Application no: H18/1319/00
Original Applicant: Lougee "J"s
63A Queen Margerets Close
London
N1 4PZ

Description: Convert Sunday School room to two storey one bedroomed dwelling

Location: The Old Methodist Church
Allenbys Chase
Sutton Bridge
Spalding, Lincs

**TOWN AND COUNTRY PLANNING ACT 1990
NOTICE OF ACCEPTANCE OF AMENDMENT**

AMENDED PLAN
11.1. A1

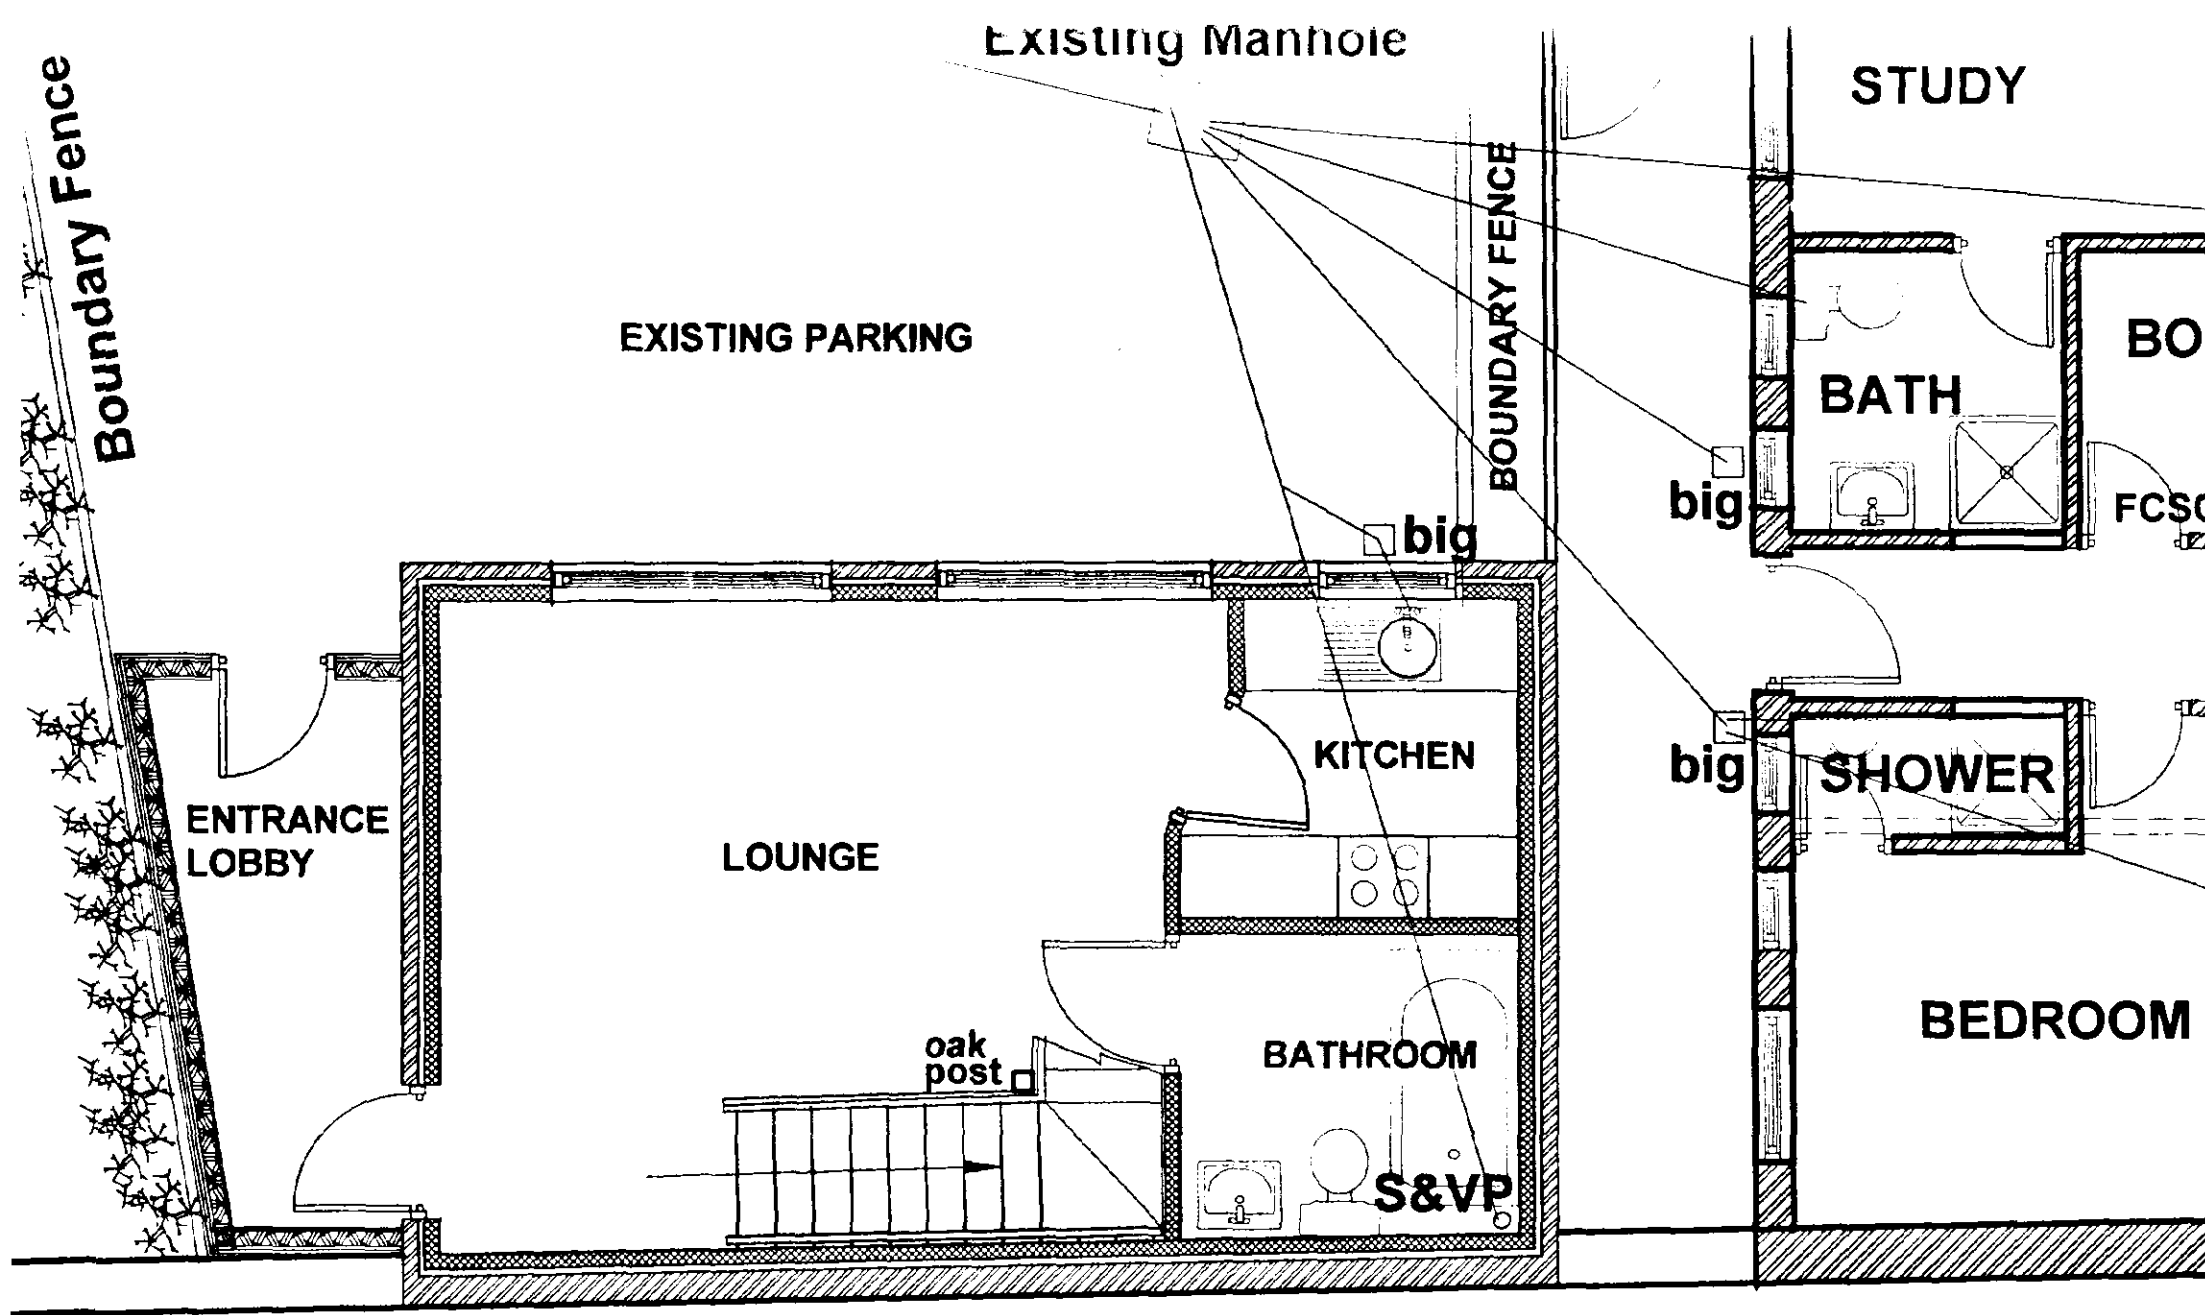
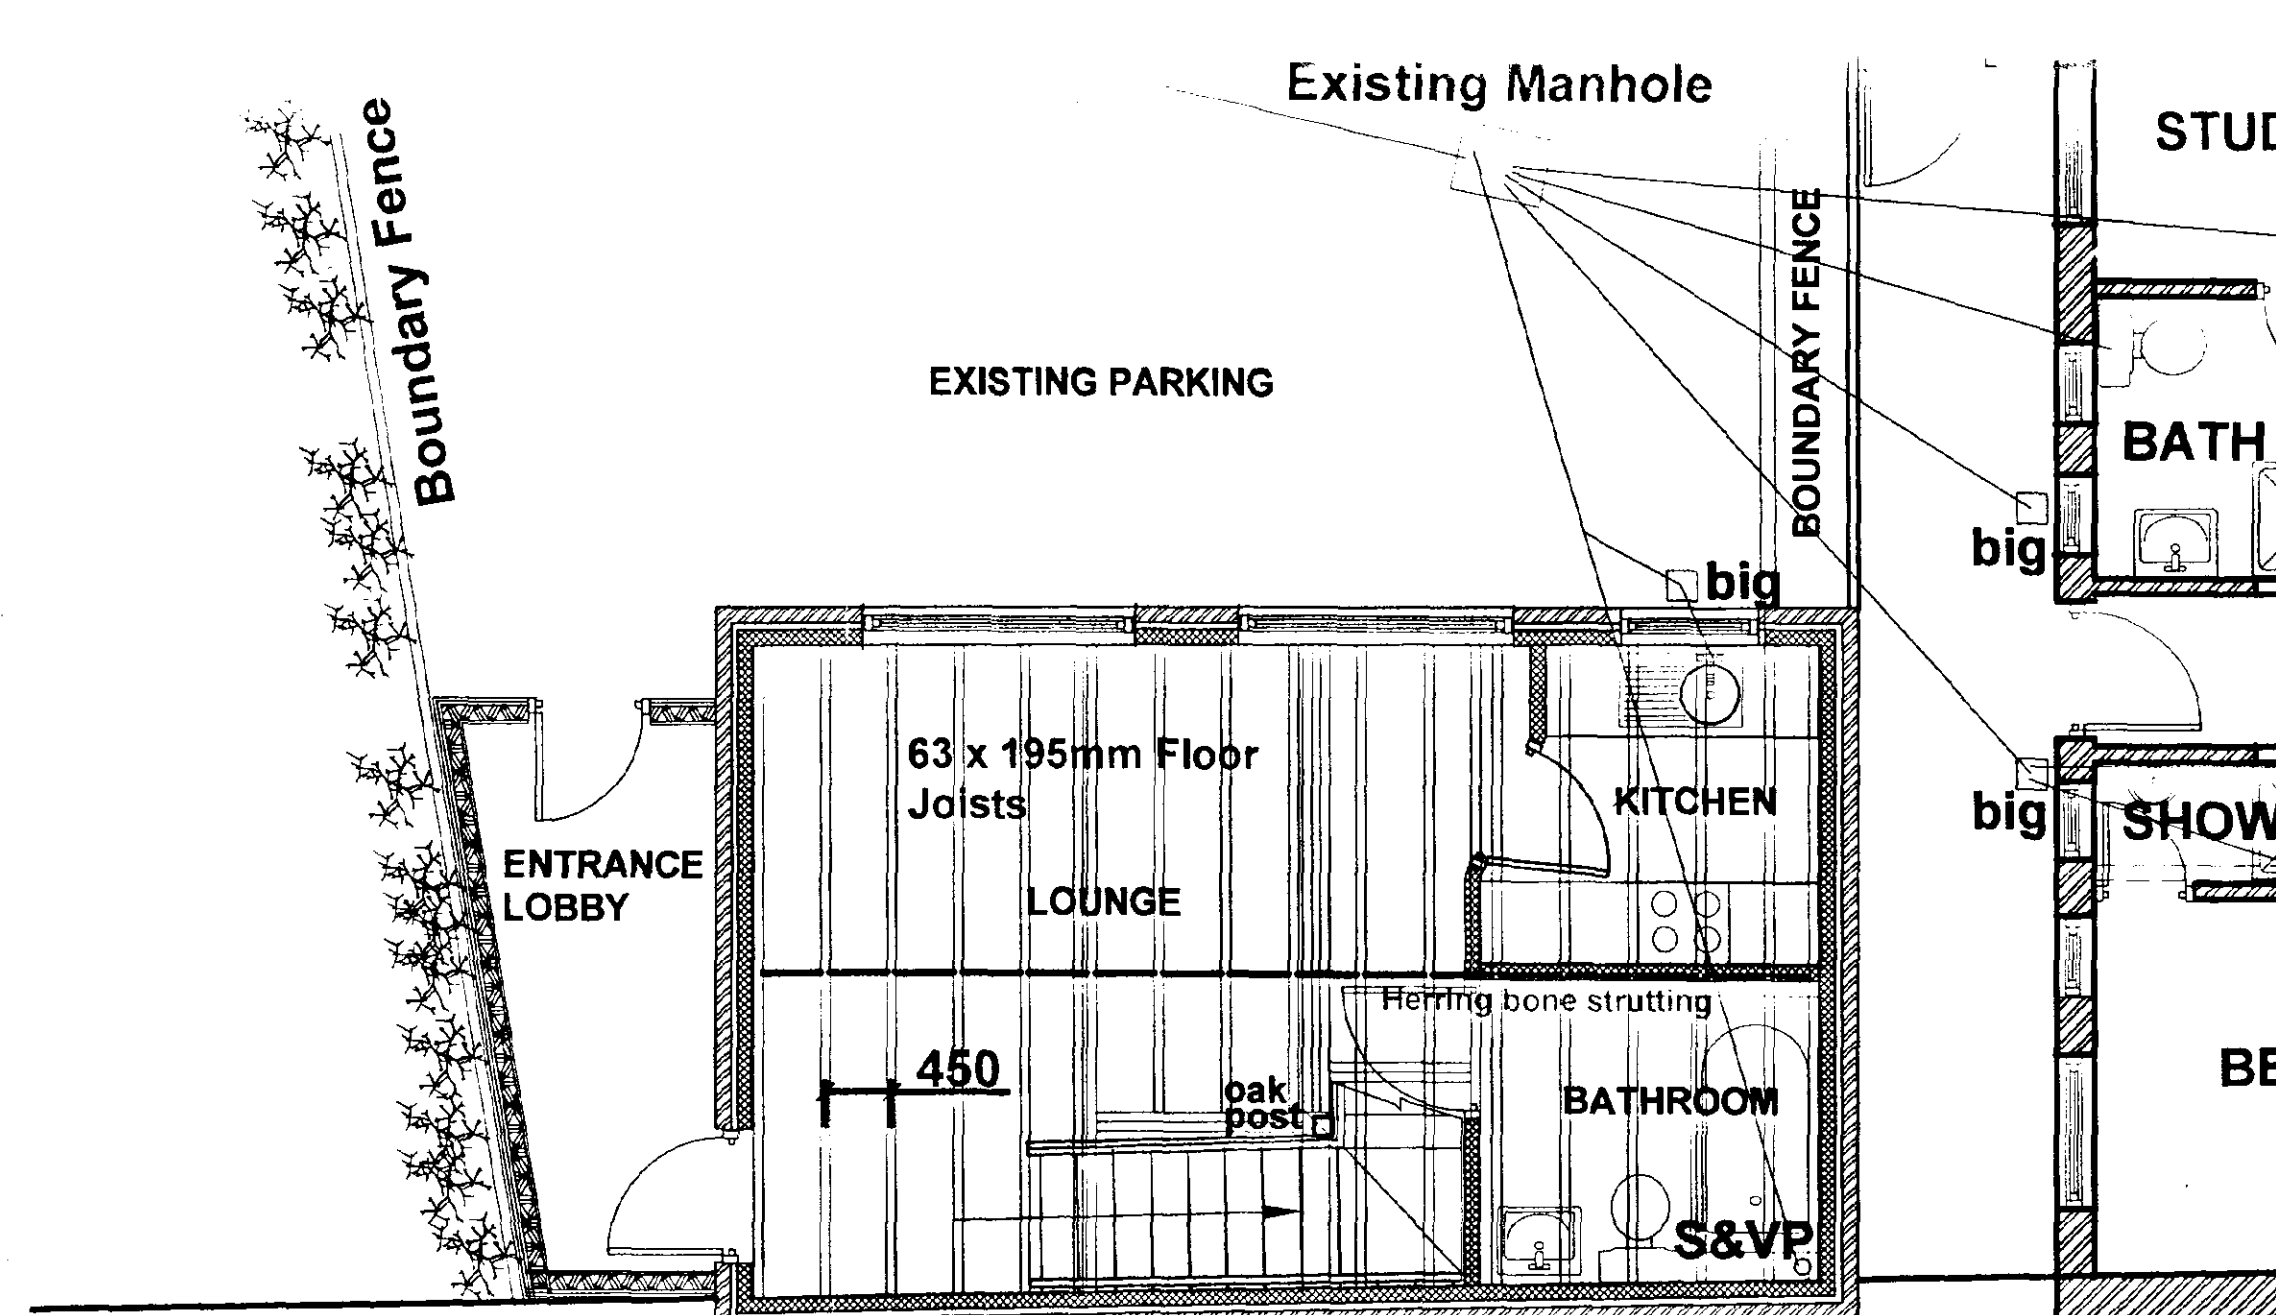
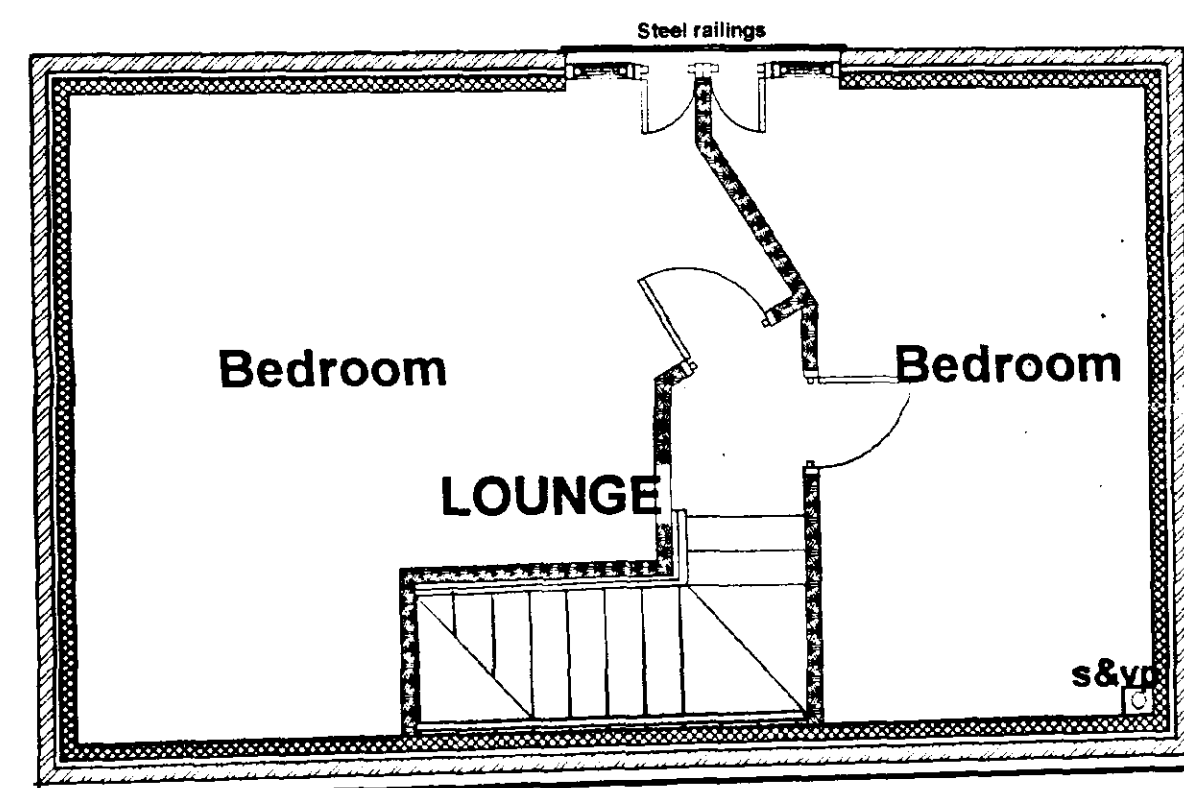
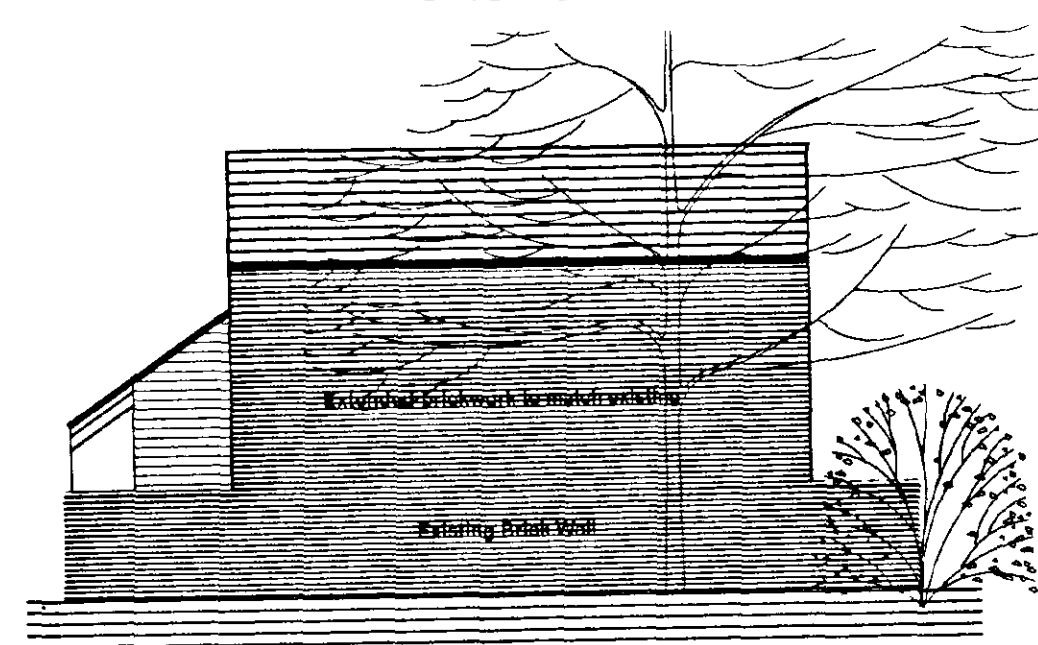
Amendment: Porch added and minor internal alterations
(dwg no.1503.AD/1)

PORCH ADDED

MINOR INTERNAL ALTERATIONS

The amended details submitted in respect of the above proposal have now been considered and there are no objections to the amendment being implemented to the extent described above.
